DECISION DELEGATED TO DEVELOPMENT MANAGER

Application No: H23-0083-21 **Applicant:** Mrs C Bettinson

Proposal: Details of elevational & cross sectional plans, windows, doors and foul & surface water disposal (Conditions 4, 7, 8 & 11 of H23-0837-20)

Location: Highfield Farm Cranesgate North Whaplode St Catherine

Drawing
FLOOR PLANS - PROPOSED
ELEVATIONS - PROPOSED
SITE PLAN

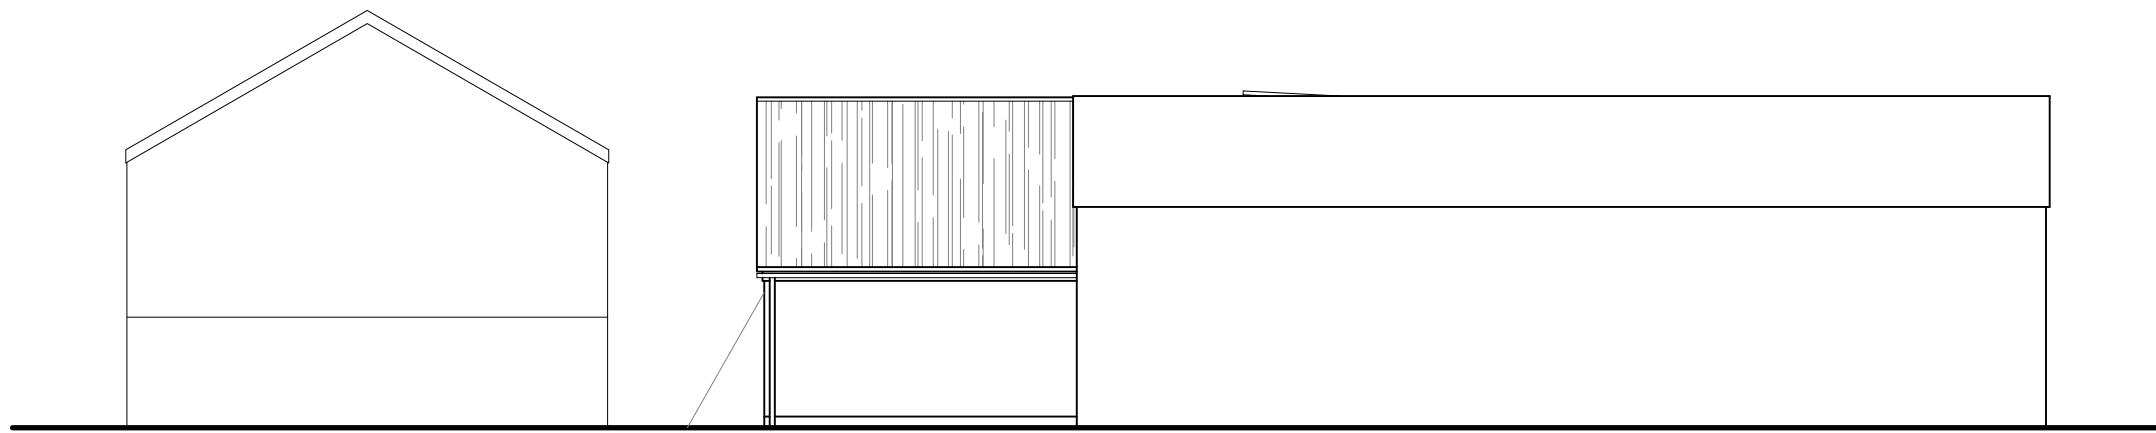
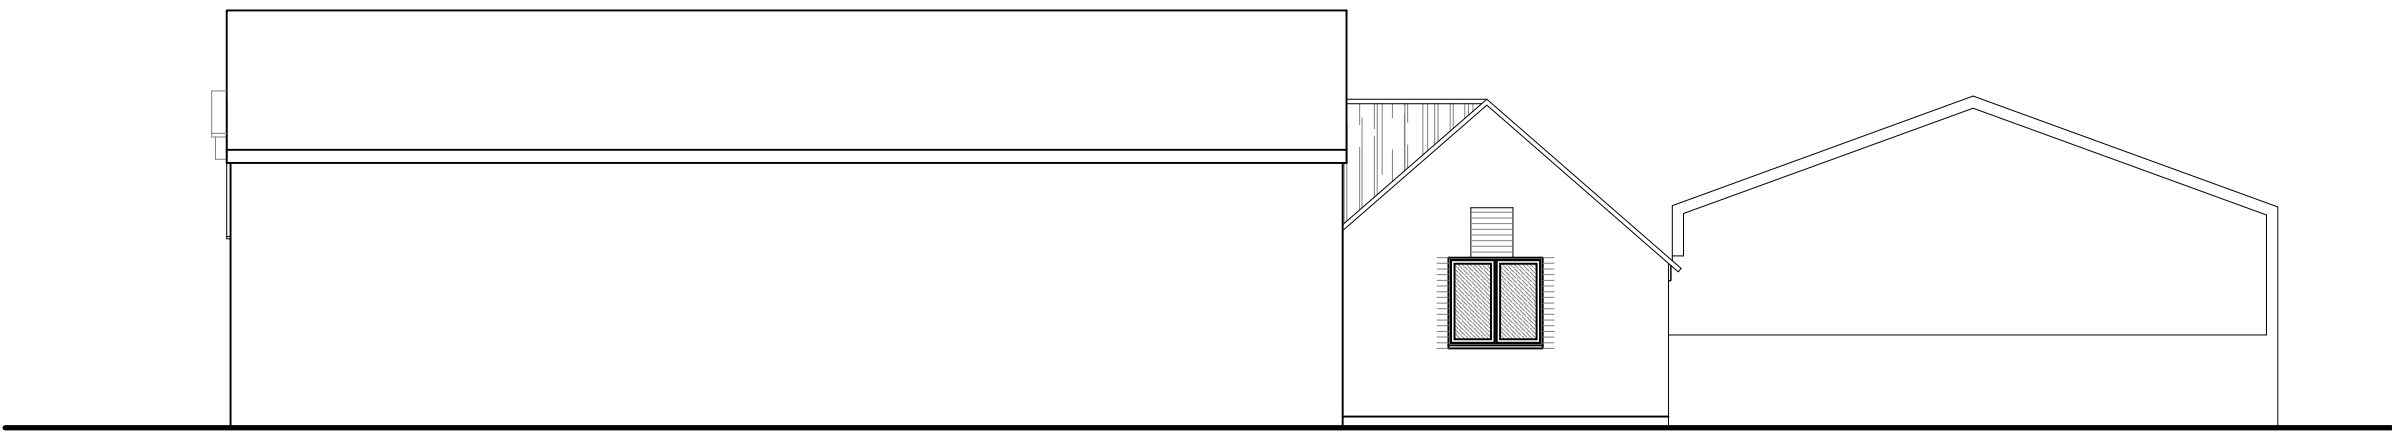
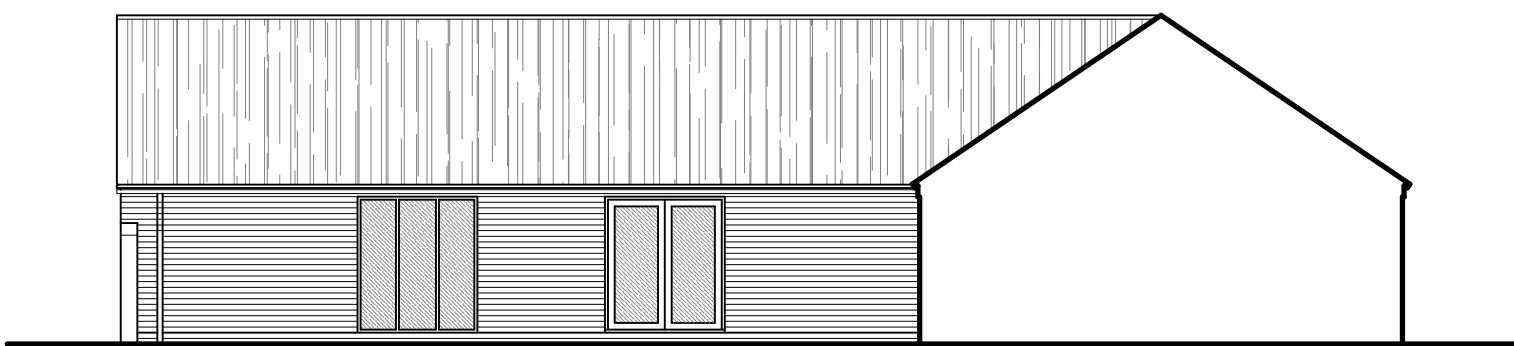
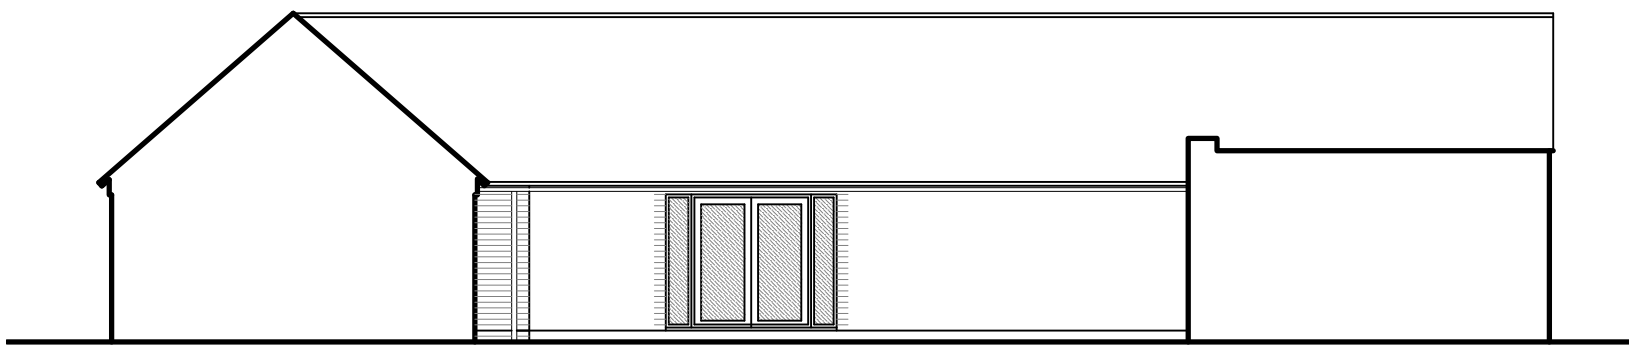
Condition 4 (Elevational and cross sectional plans) - The submitted cross-sectional plans are considered acceptable. The main elements of the original building would be retained.

SITE PLAN 1:500

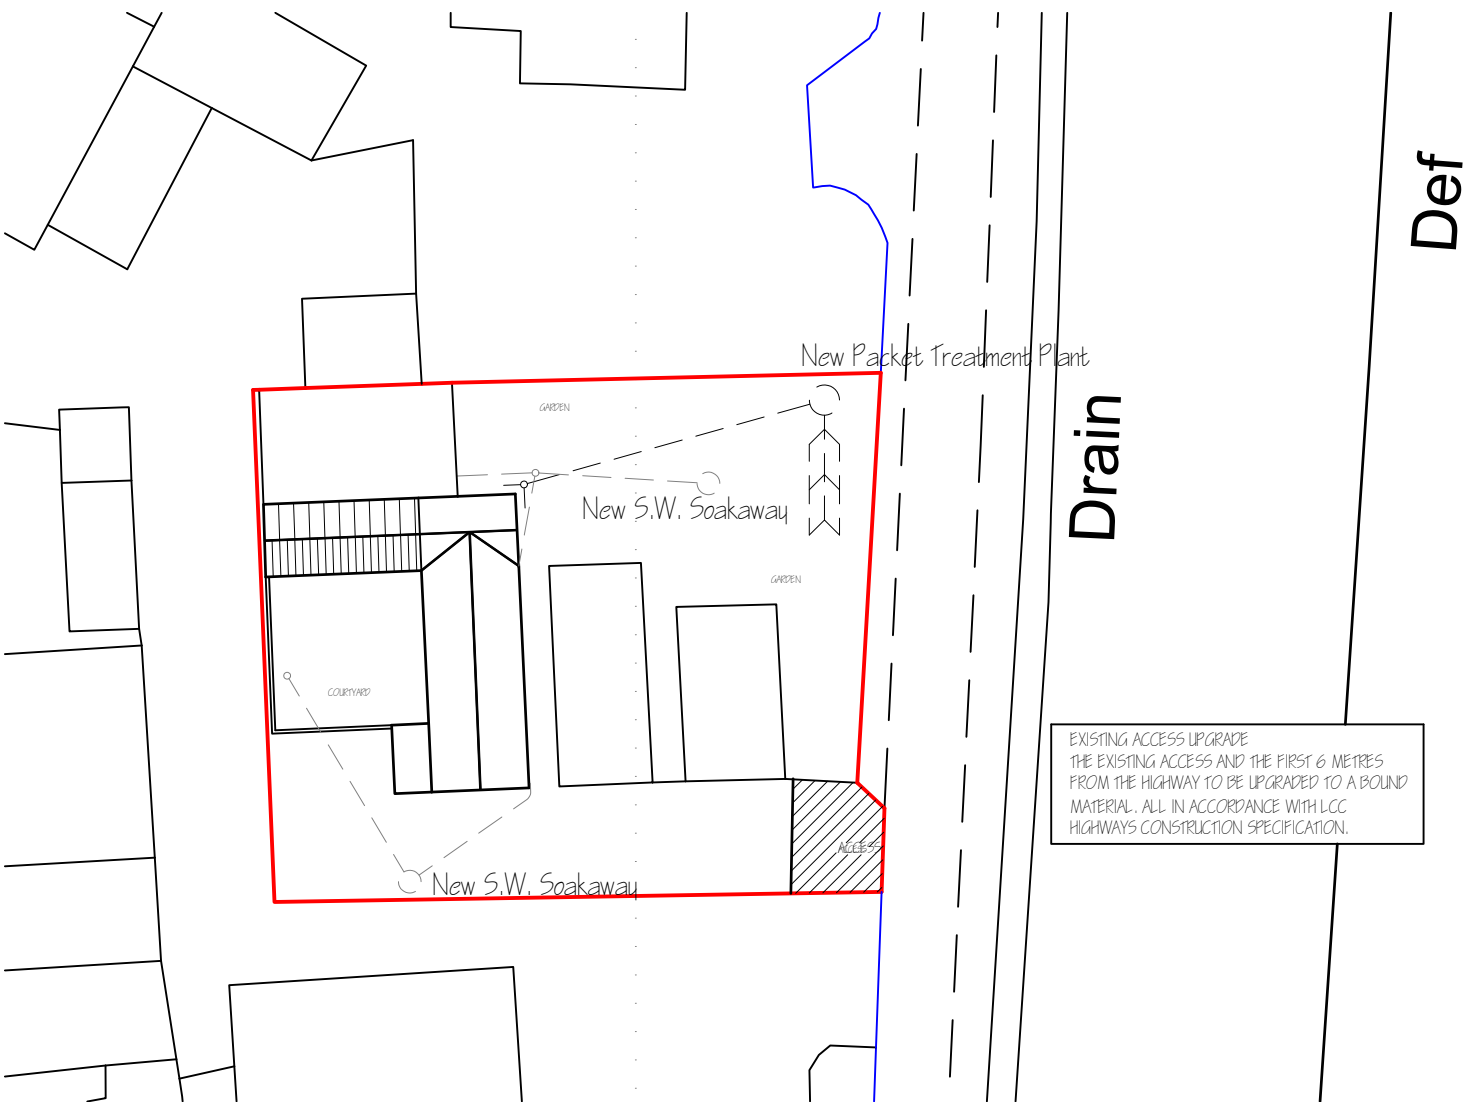
Condition 11 (Details of the proposed means of foul and surface water disposal) - Foul water would be disposed of to a package treatment plant, with drainage field. Surface water would be disposed of to soakaways. The details are considered acceptable.
